Application No: EP/35/22/HH
Site Address: West House South Strand East Preston BN16 1PN
Description of works: Erection of single storey front extension, first floor front/side extension and alterations to fenestration/openings.

Thank you for your internet representation made on 19th May 2022 which has been recorded as an objection with the comments as follows:

E ELEV

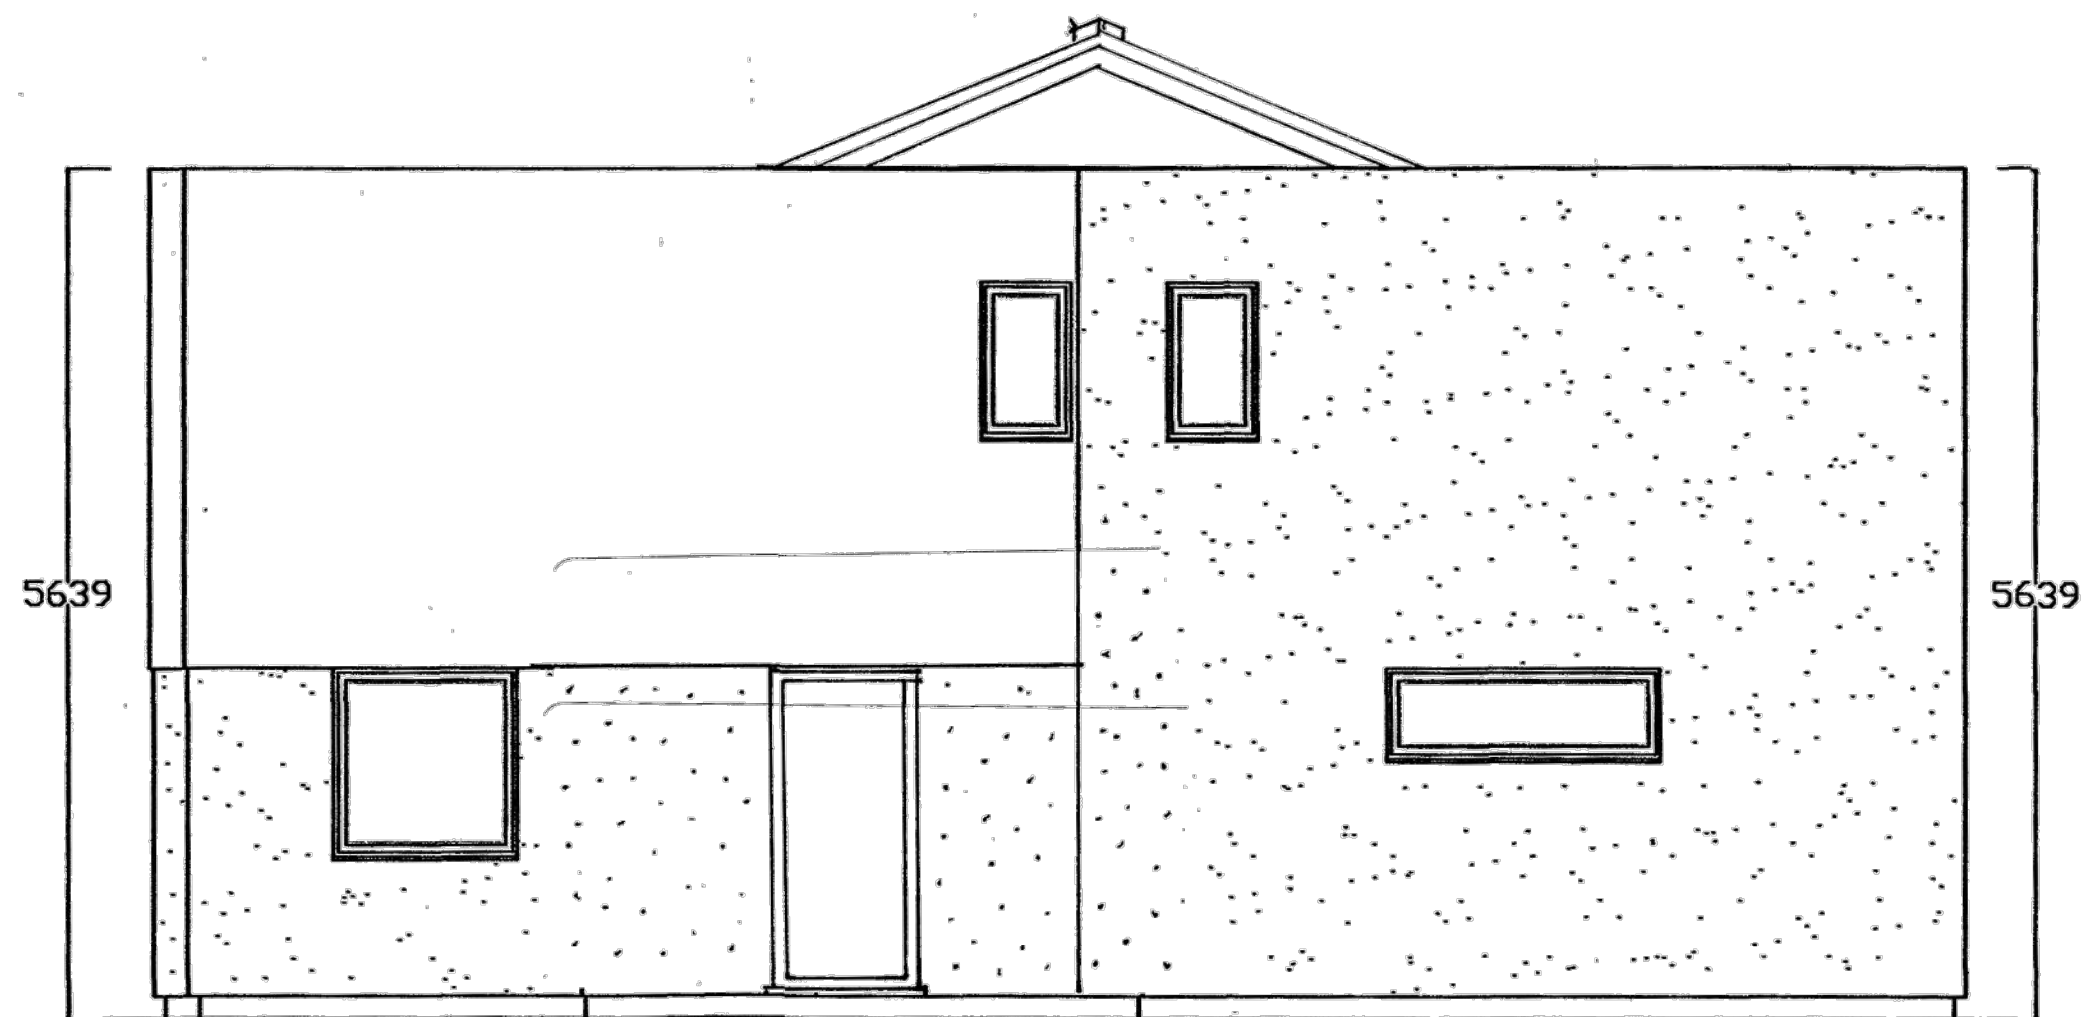
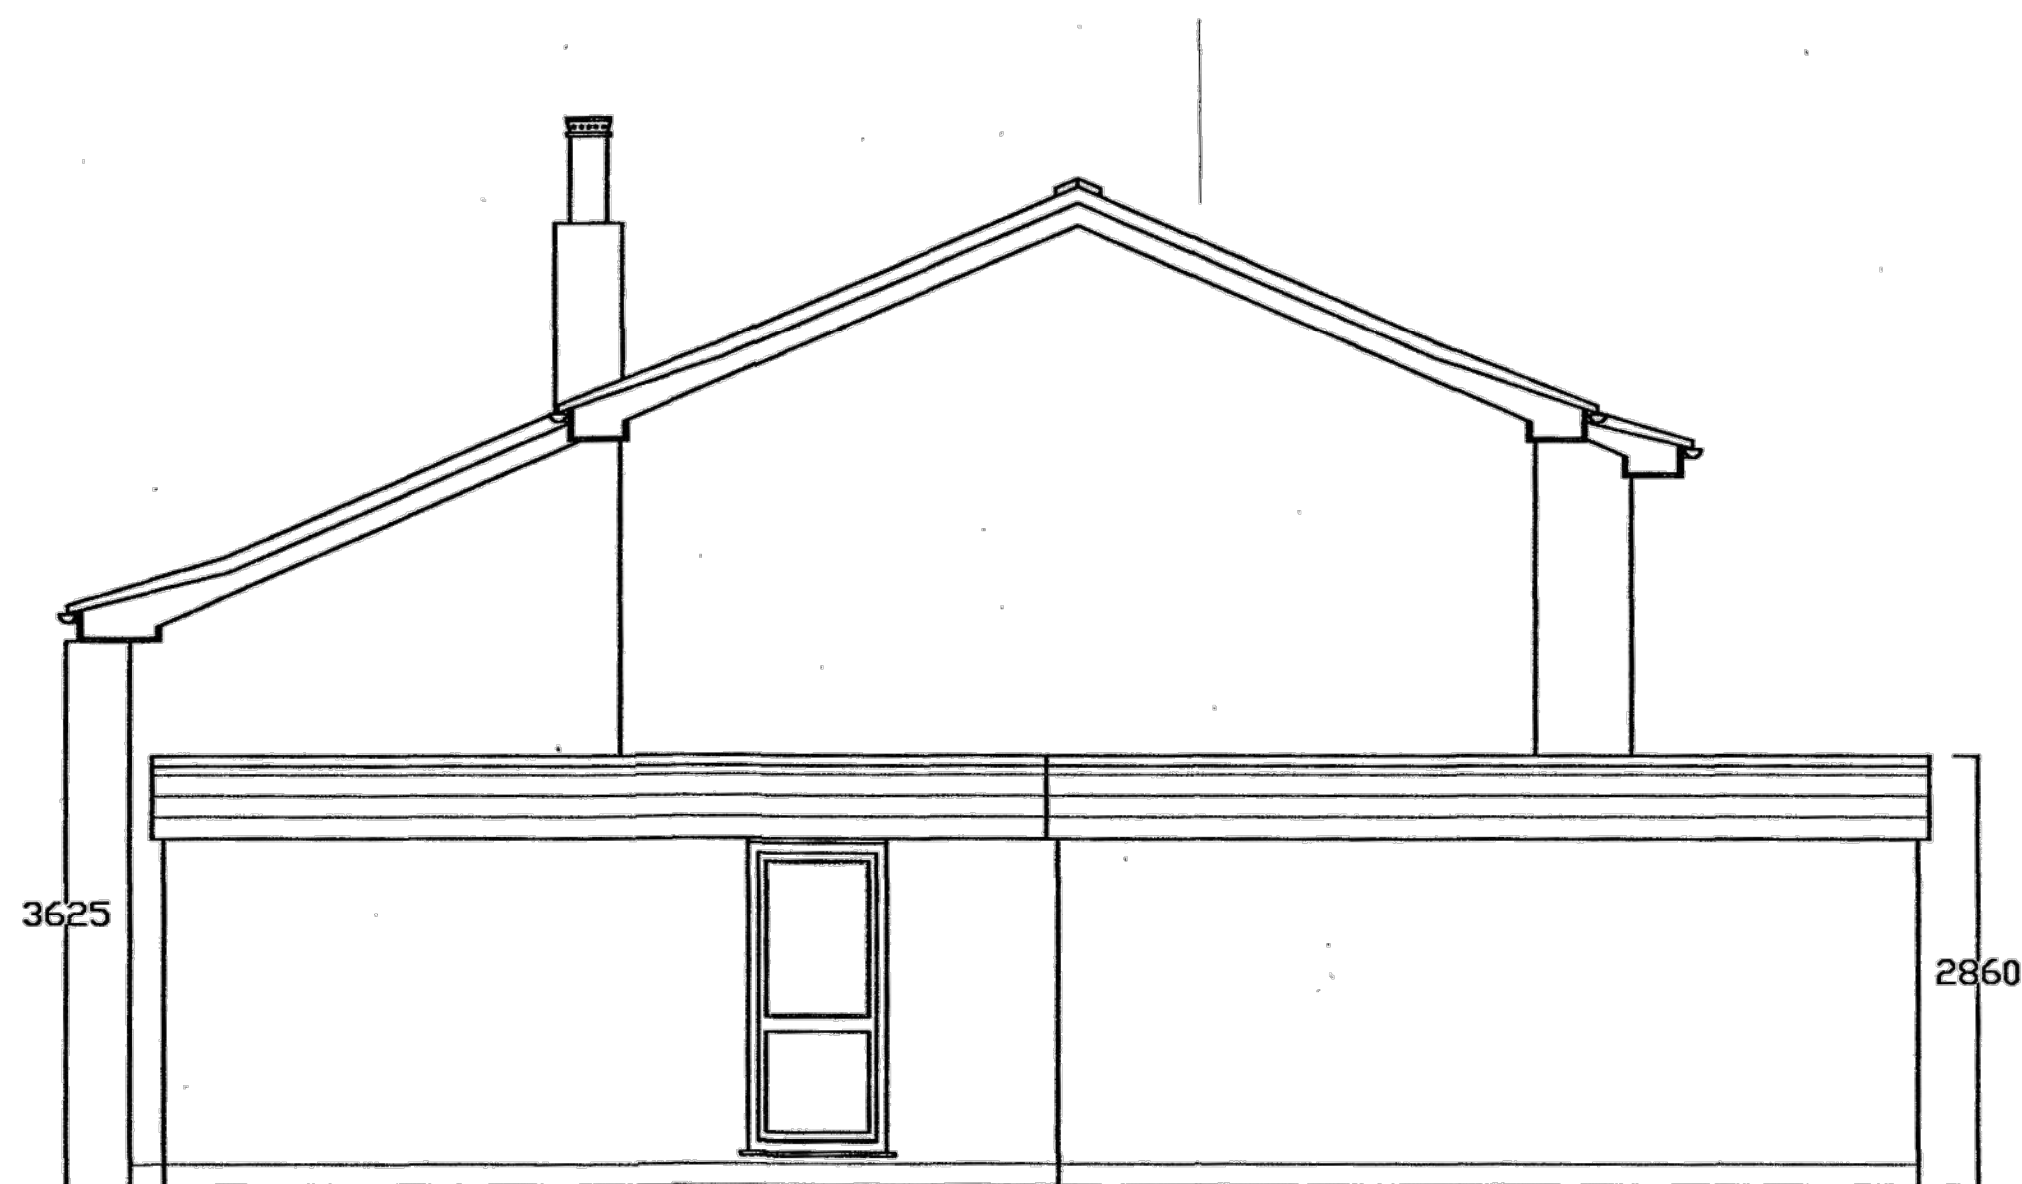
While acknowledging the fact that the extensions proposed are on the footprint of the existing dwelling, the extension upwards is awkward and not integrated with the original house and roofline. The eastern elevation especially would be overbearing on the neighbouring property and introduce an unacceptably bulky rectangular element into the street scene when viewed walking along the road. The addition of enlarged fenestration on the ground floor and new first floor windows could also damage the amenity of neighbouring properties.
